Rezoning Transportation Analysis

Petition Number: 2023-095

Date	Description
9-28-23	First Review (IW)
11-27-23	Second Review (ME)
12-20-23	Third Review (IW)

**C200**

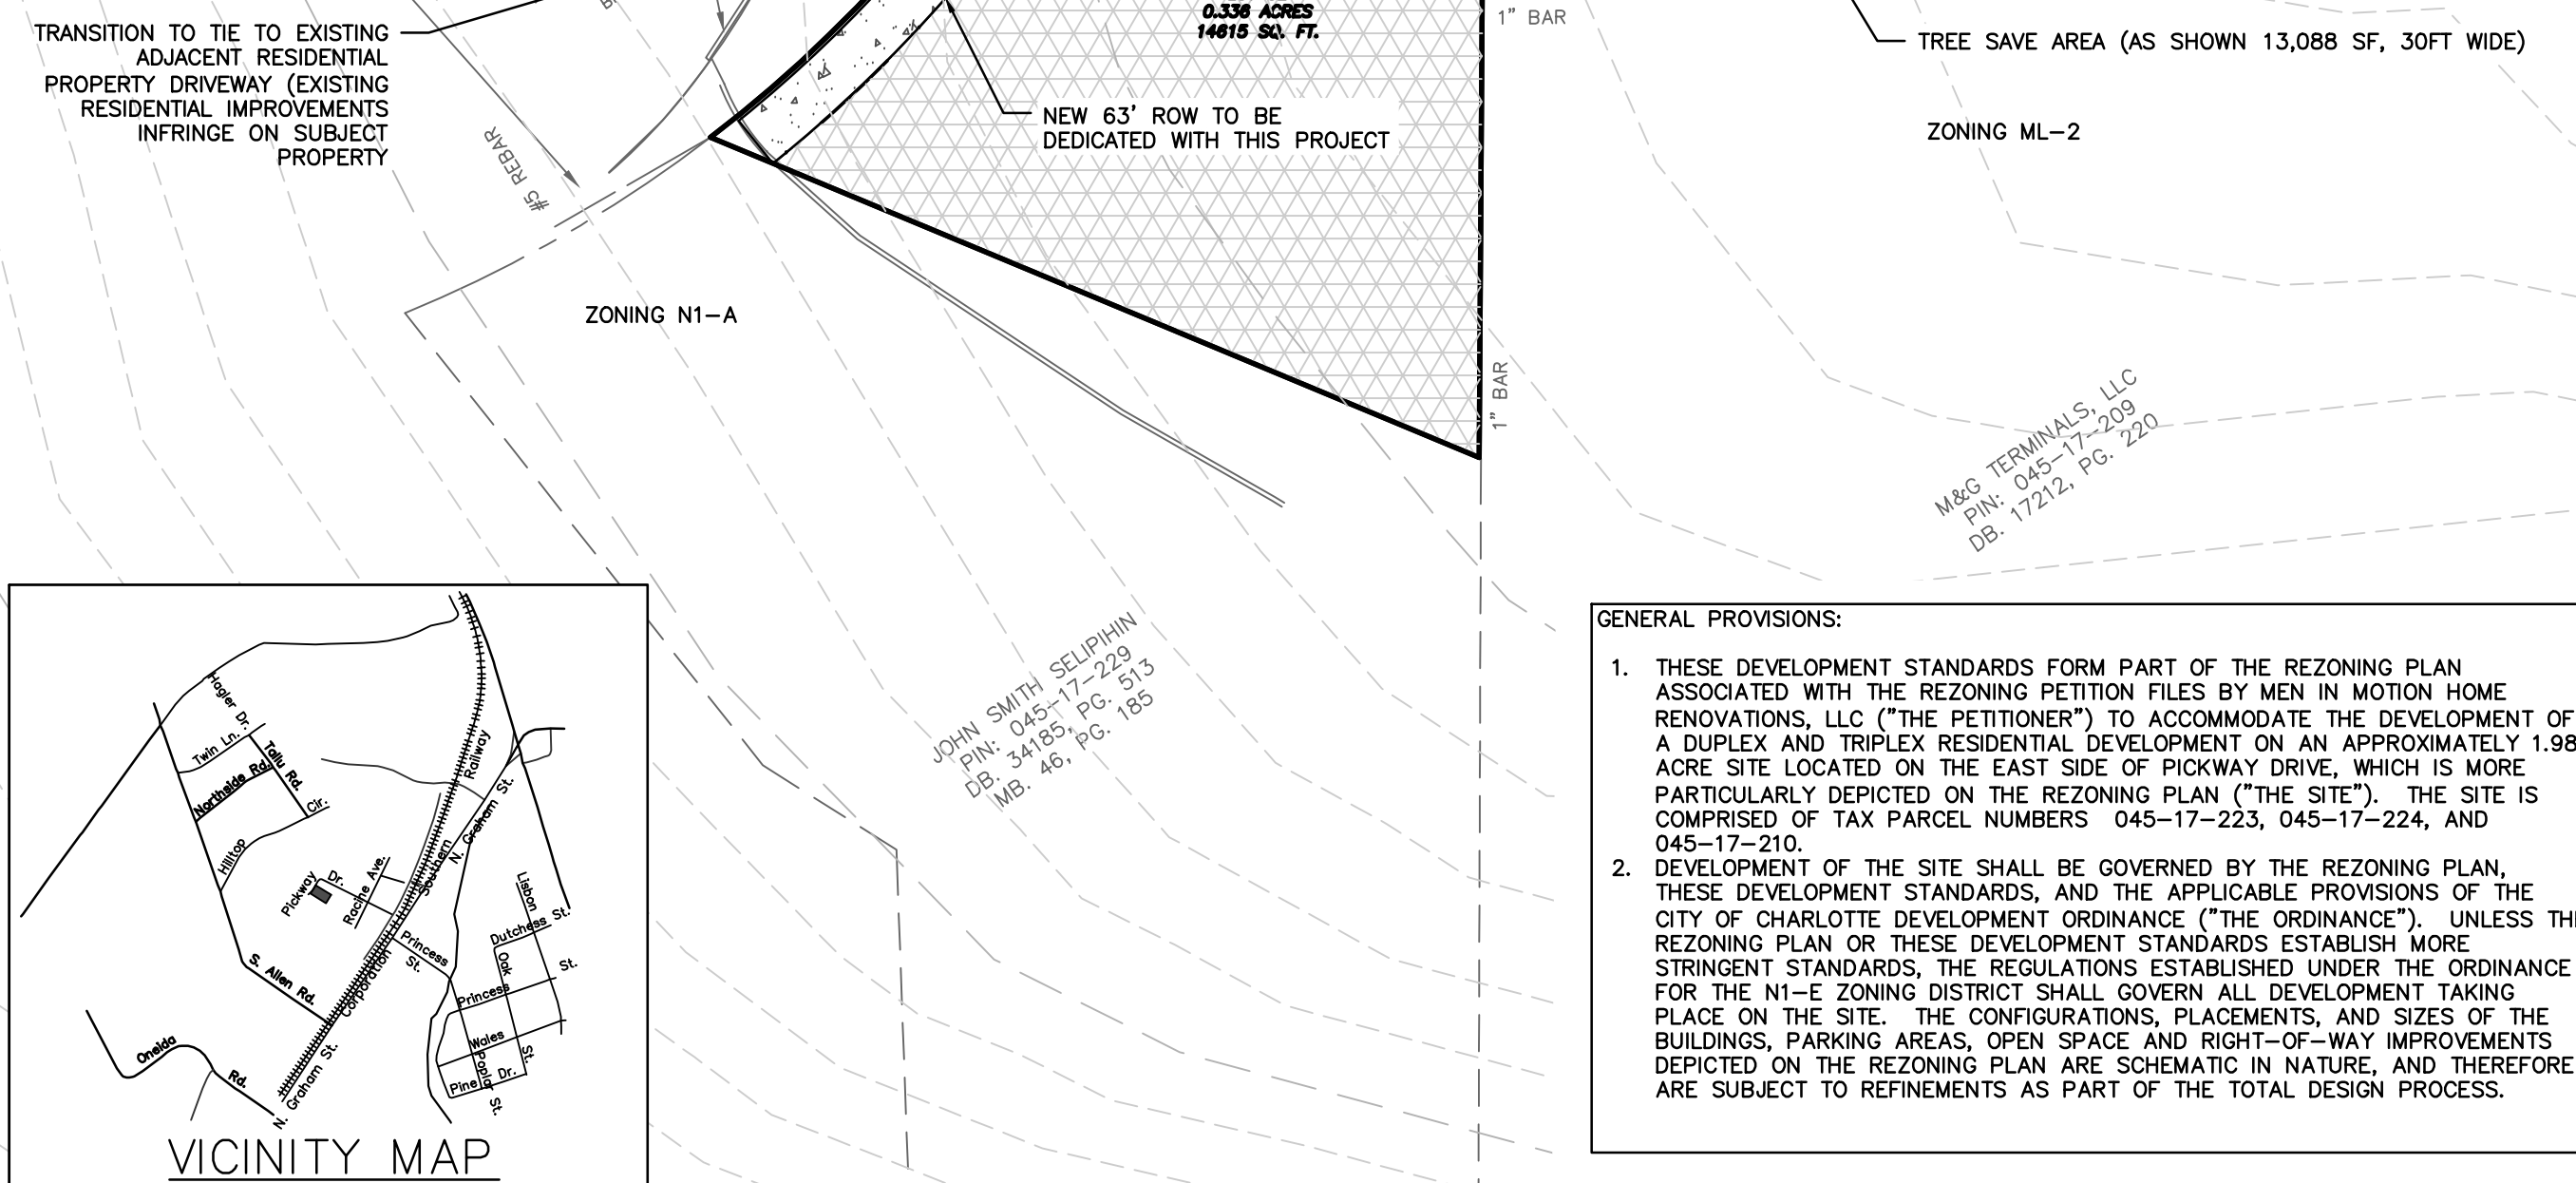
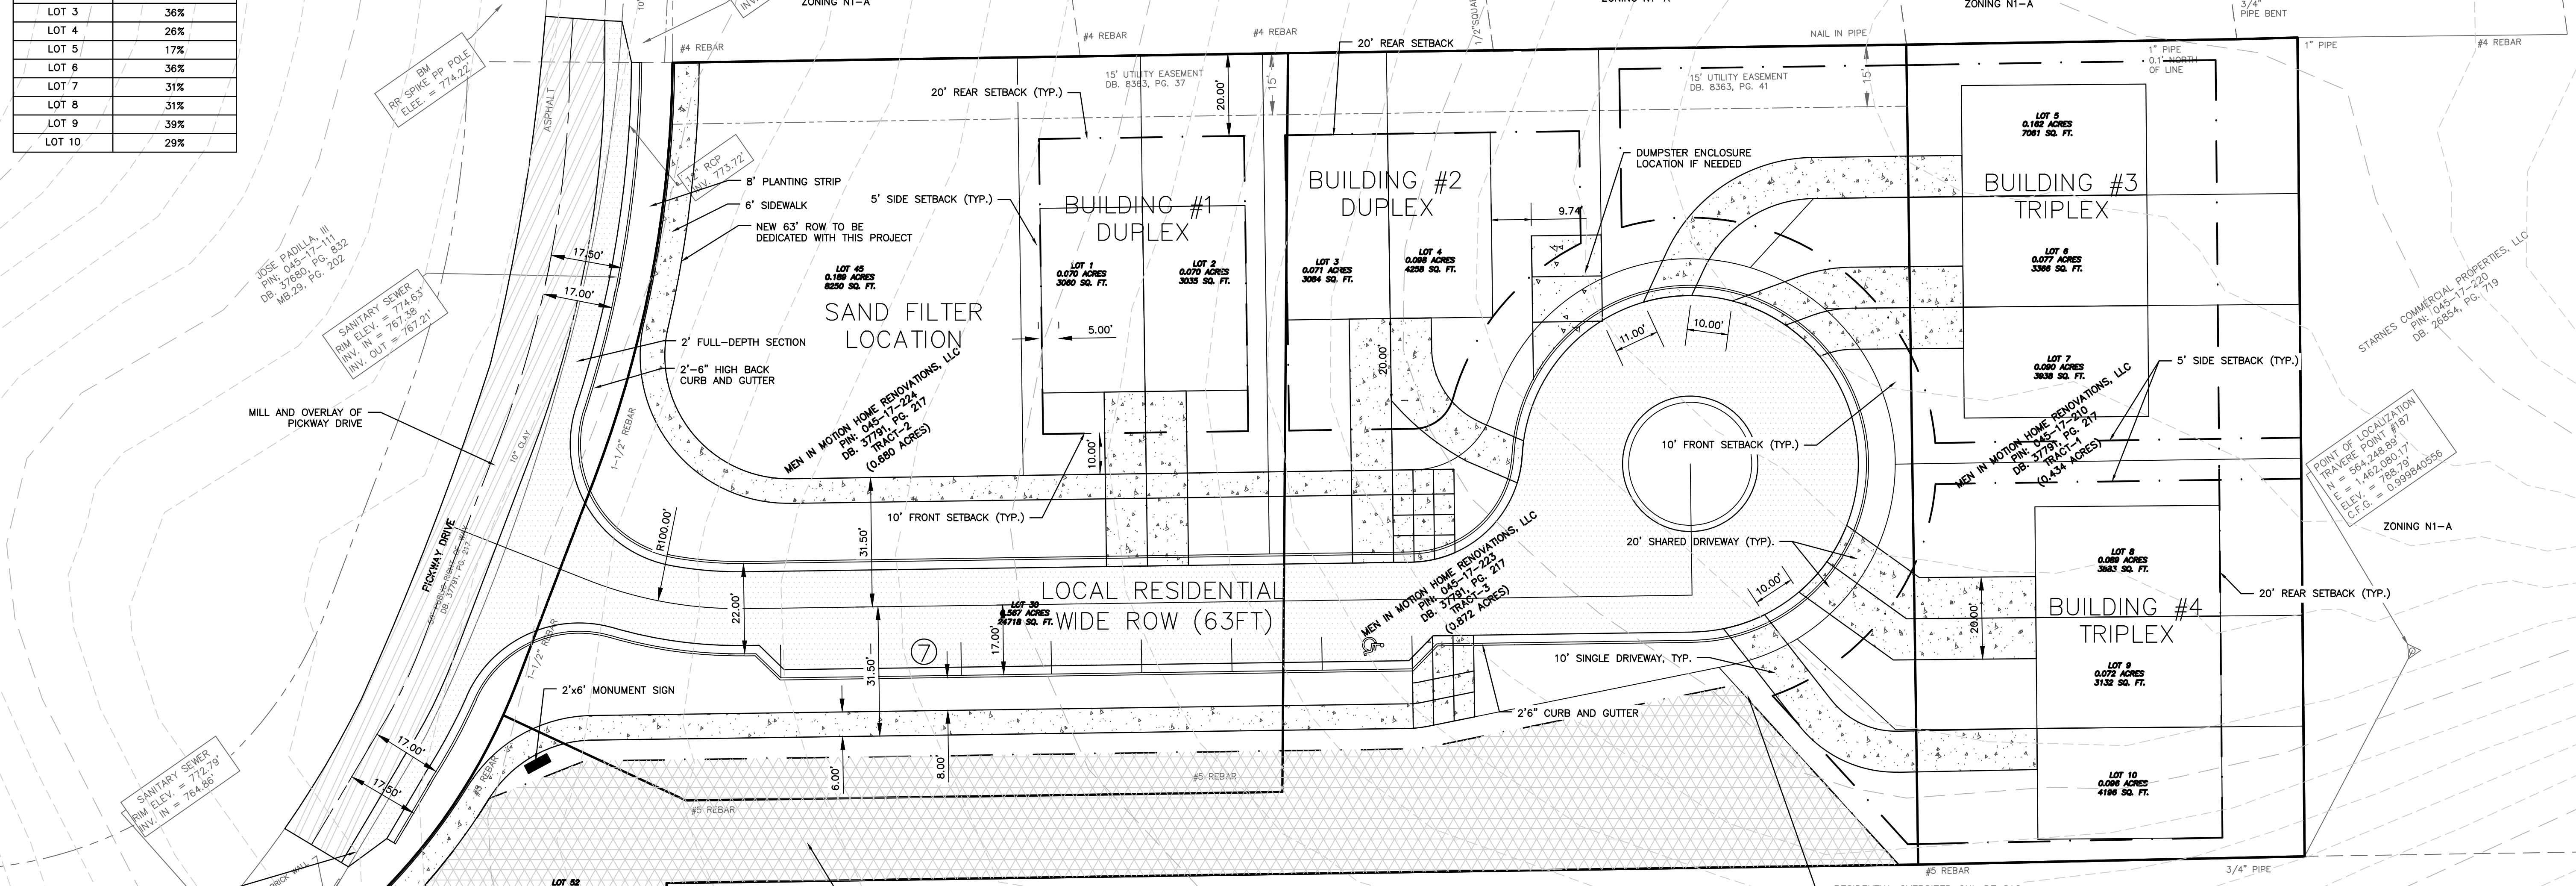
3. Outstanding Comment: Revise site plan and conditional note(s) to commit to dedicate 31.5 feet of right-of-way from the road centerline. The site plan shall label and dimension the right-of-way from the road centerline.

Clarifying Comment 11-27-23: Please revise site plan and conditional note to commit to mentioned right-of-way dimension with labeling and dimensioning from the roadway centerline.

- Outstanding Comment:** Revise site plan and conditional note(s) to commit to an 8' planting strip and 6' sidewalk per the CLDSM U-03A2 along Pickway Drive per UDO Article 33.

Clarifying Comment 11-27-23: Please revise conditional note(s) to commit to an 8' planting strip and 6' sidewalk per the CLDSM U-03A2 along Pickway Drive per UDO Article 33.

Sidewalk should extend across the entire frontage, including at the intersection of the proposed public street and Pickway Drive as well as fully to property line.

Comment 11-27-23: Please revise conditional notes to commit to ADA parking..

Comment 11-27-23: Please revise conditional note(s) to commit to milling and overlaying the entire section of Pickway Drive across development frontage.
